# KITTITAS COUNTY

## DEPARTMENT OF PUBLIC WORKS

**TO:** All Staff  
**FROM:** Public Works Plan Review Team  
**DATE:** February 17, 2023  
**SUBJECT:** SX-23-00002 Mannes

ERIC HOHMANN
 TOPOGRAPHIC SURVEY

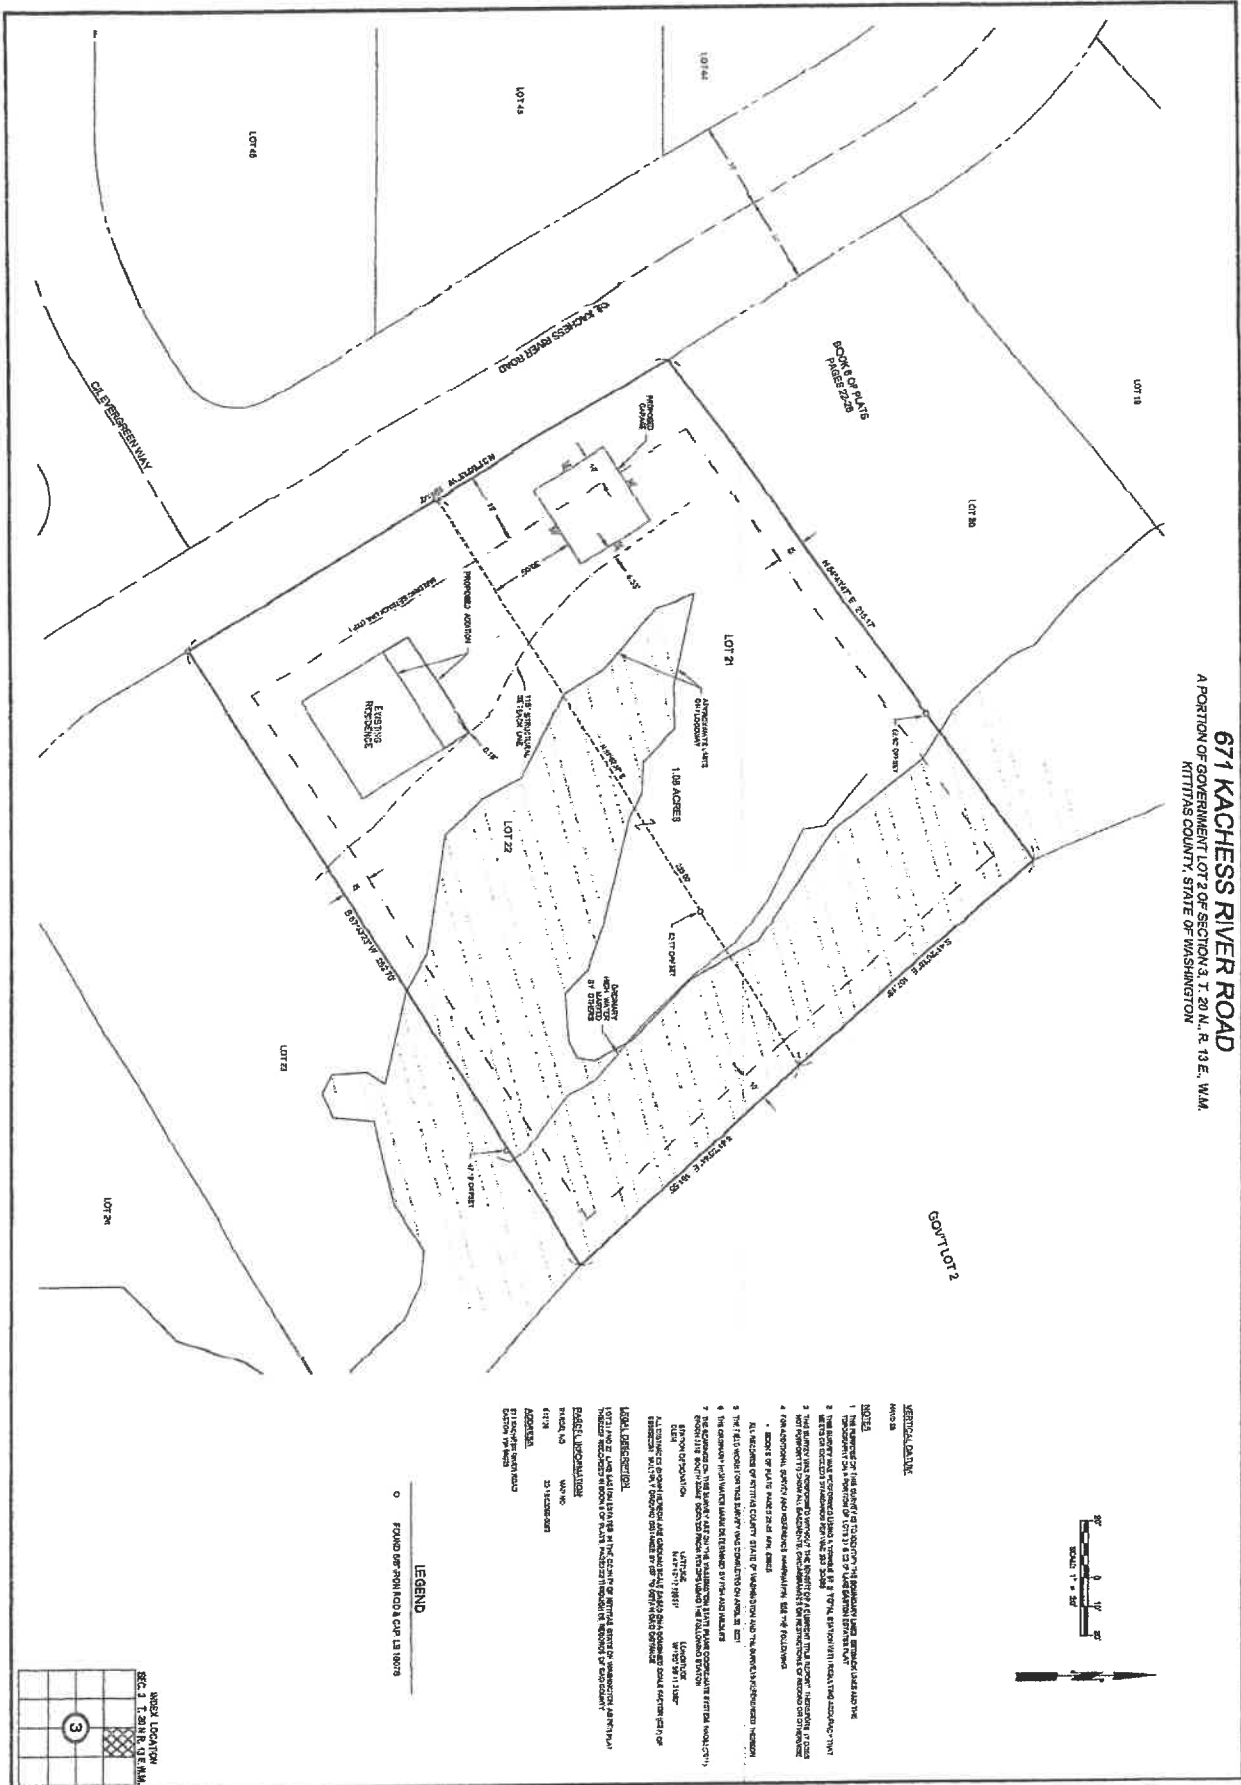
<b>ENGINEERING</b>	No comments
<b>FLOOD</b>	The submitted site plan meets Public Works needs for understanding the location of the proposed development relative to the floodway and special flood hazard area. Since the proposed development is outside the floodway and special flood hazard area, a floodplain development permit is not required.
<b>WATER MITIGATION/ METERING</b>	No comments
